17 March 2016

Our Ref: 2016/124994  
File No: R/2015/21/A  
Your Ref: SSD 7080

**RE: Exhibition of proposed mixed use residential and retail development at 80-88 Regent Street, Redfern (SSD 7080) - OBJECTION**

DRAINAGE CONCEPT PROPOSAL
GROUND FLOOR PLAN

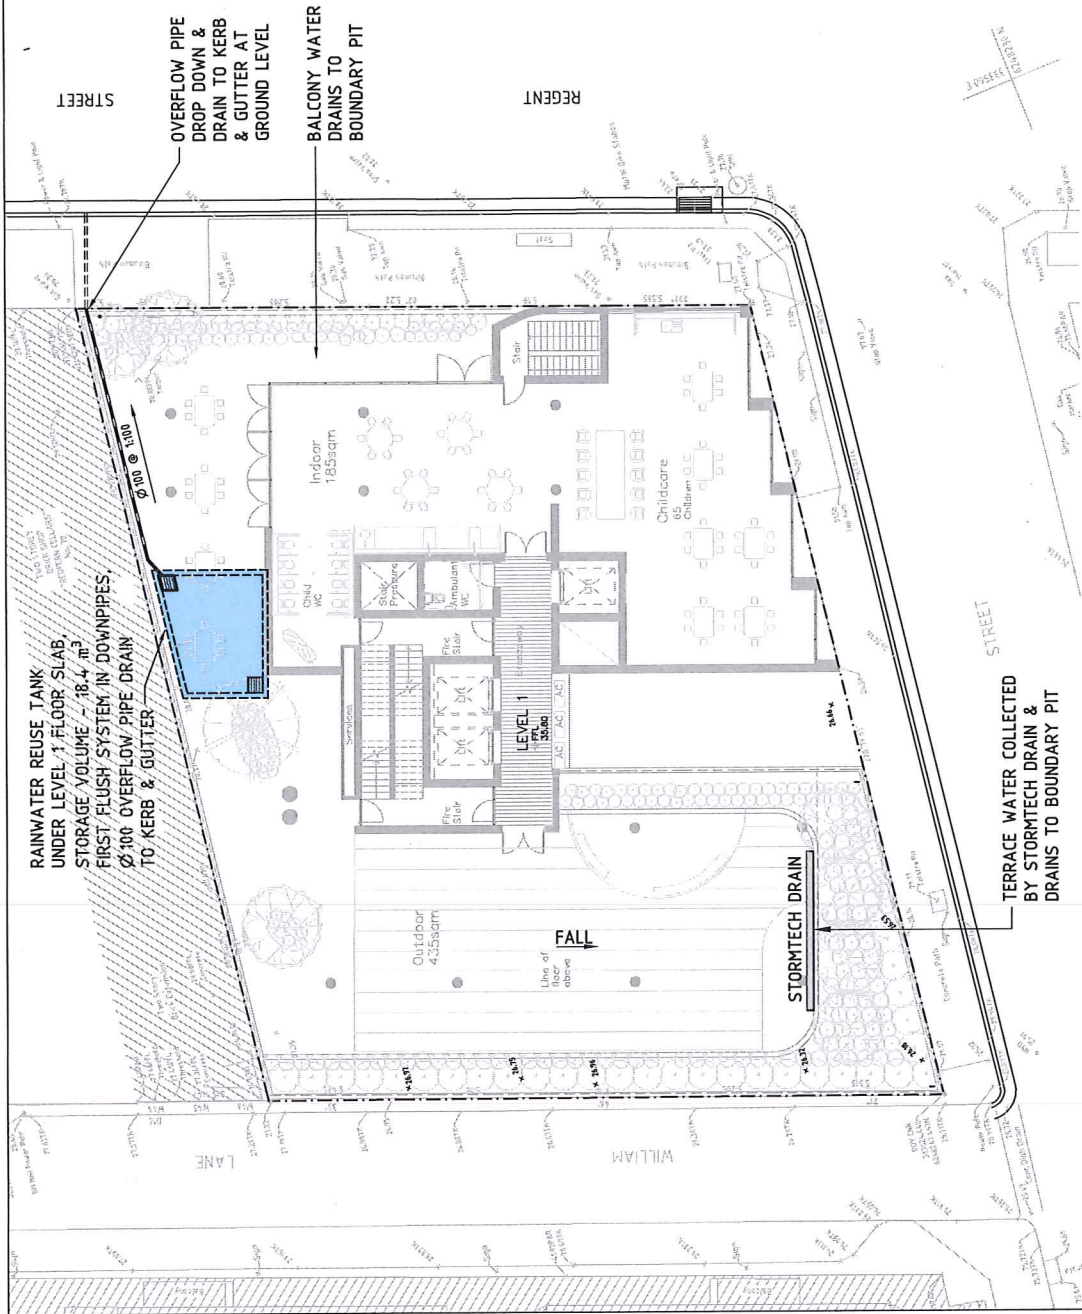
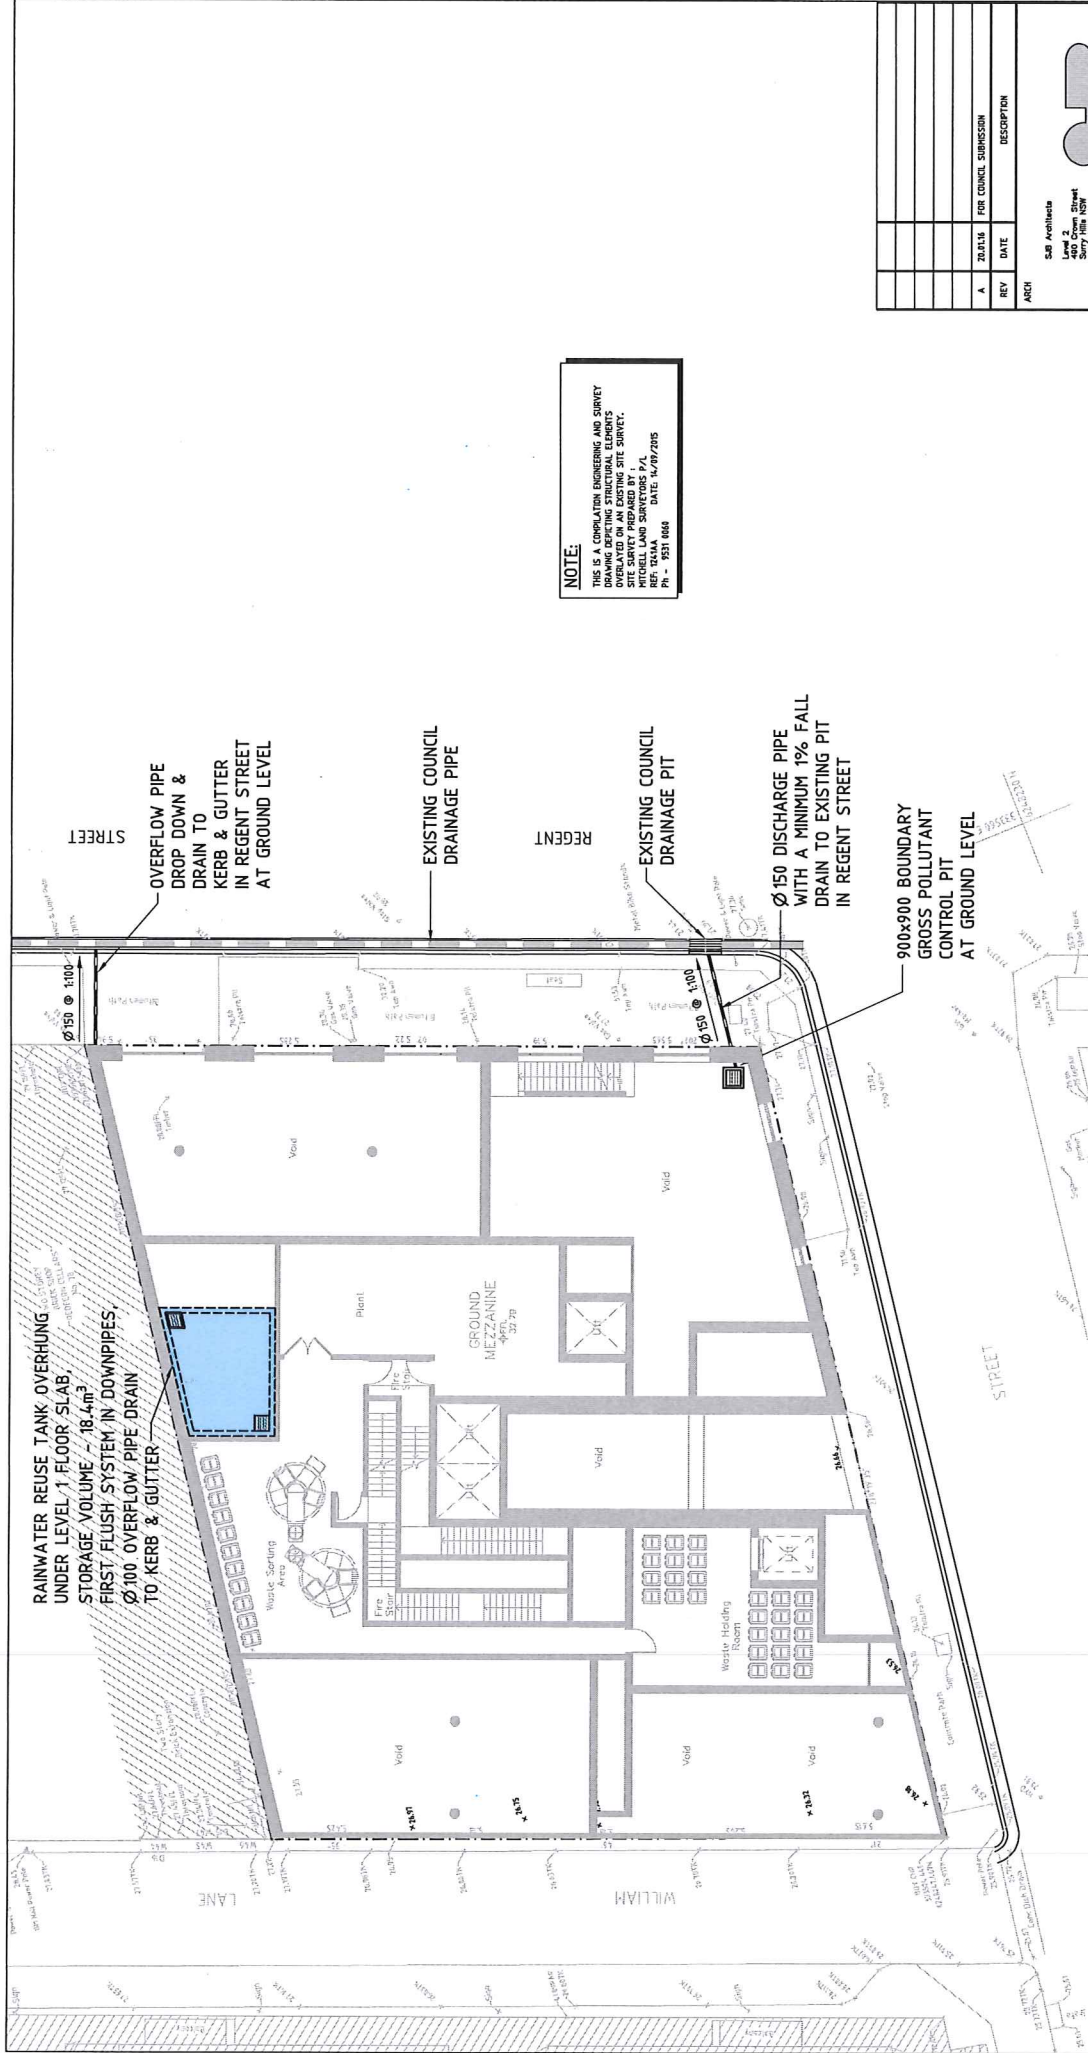
25. On-site detention (OSD) has not been included on the submitted Drainage Concept plans. An OSD system is required for the development's stormwater drainage system as per the Sydney Water On-site Stormwater Detention Guide.
26. The Drainage Concept plans shows downpipes on the outside of the northern boundary wall, which has a zero setback and an adjoining building built to the boundary.
27. Existing City of Sydney stormwater infrastructure (pit and pipe) is located at the Regent Street frontage of the development site. It is recommended that the drainage outfall from the site be connected to this infrastructure where possible.

- The applicant is to consult with Sydney Water for OSD requirements and specifications.
- Amended Drainage Concept plans are to be submitted that address the issues raised above.

01. View from the sun_9am

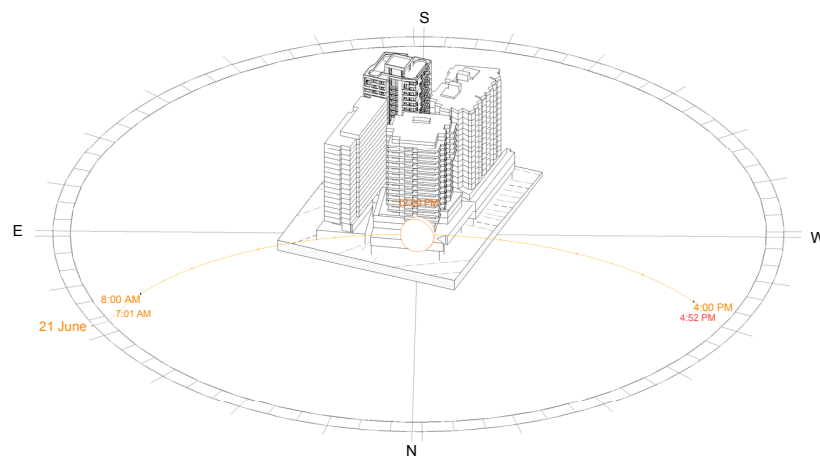
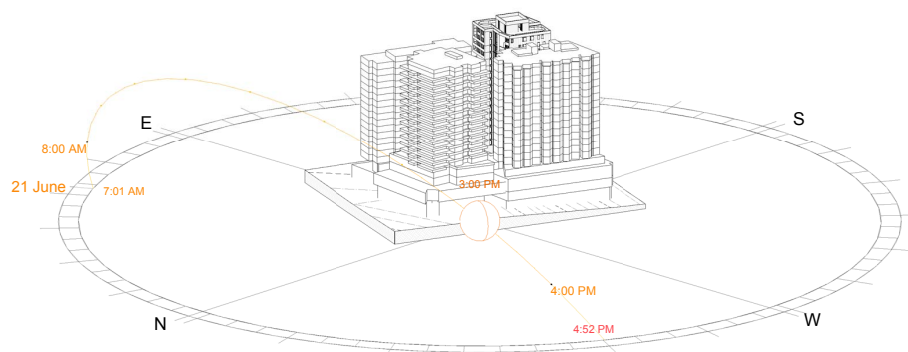
9. The proposal claims that it achieves 70% solar access. However, when the Solar Access 9am-3pm drawing (DA3201) is read in conjunction with the View from the Sun drawing (DA 3011) it appears that it does not meet the requirements of the Apartment Design Guide (ADG). Examples of non-compliances are as follows:

- the Solar Access Schedule claims that Apartment L2.06 achieves 2 hours of sun. When this is verified against the View from the Sun, it is only seen at 10am, 10.30am, 11 am and 11.30am - a period of 1.5 hours. The balcony receives sun for approximately 1 hour and the last 30-45 minutes the sun is in the living room. At around 11am both the living and balcony receives sun;

- Apartment L2.01 can only be seen in the View from the Sun between 9-10am. This is a period of 1 hour and should not be include in the Solar Access Schedule;

- A more accurate Solar Access Schedule is required to determine the number of apartments that achieve solar access for 2 hours in mid-winter, in accordance with the ADG requirements.
